From: Moor Construction LTD GMAIL [REDACTED]
Sent: 23 August 2021 10:53
To: Nicola Moore
Subject: AB/102/21/DOC
Attachments: 200042_104_proposedfloorplans-A1 SHEET.pdf

In response to the letter dated 18th August 2021 from Neil Crowther, regarding skirting and architrave we propose to use the same as already in place, please see the links for this.

PROPOSED FIRST FLOOR PLAN (1:50)

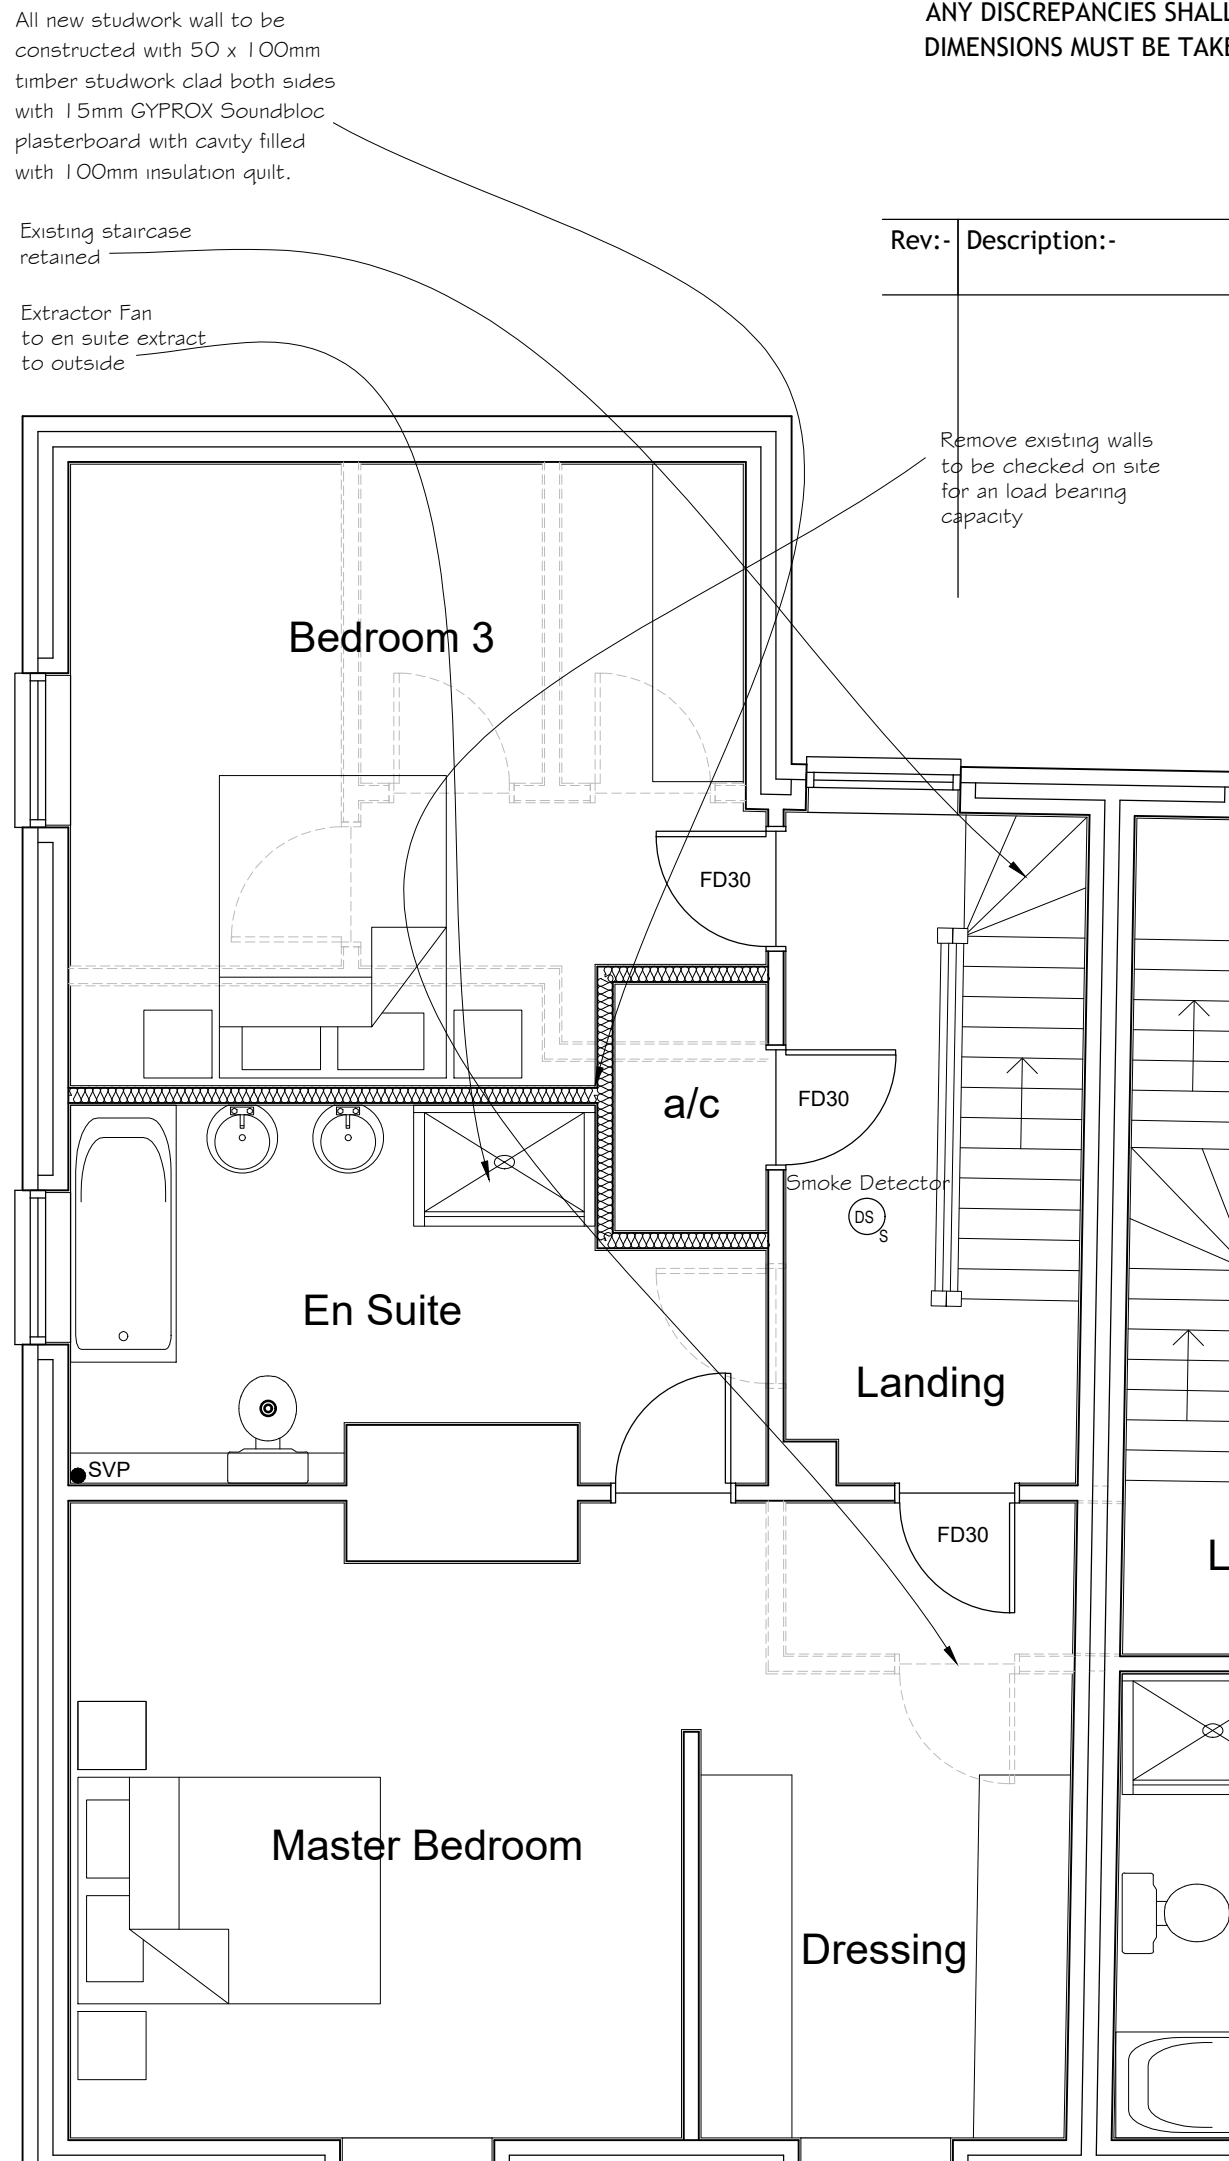
Reference the draining and electrical in bathrooms and kitchens:

The drainage is as per the drawings (see attached) and is boxed in so there is nothing visible, this goes into the basement of the property so there will be no external works for drainage.

Electrical system, I can only assume that you are referring to the extraction. Again this is totally boxed in within the building so nothing is visible.

On the outside the kitchen extraction will be behind an existing air vent at the front of the property.

For the bathrooms, externally they will exit through a grill already in place so no works.

Low level, the kitchen and utility room will exit into the courtyard which will not be visible other than a small grill.
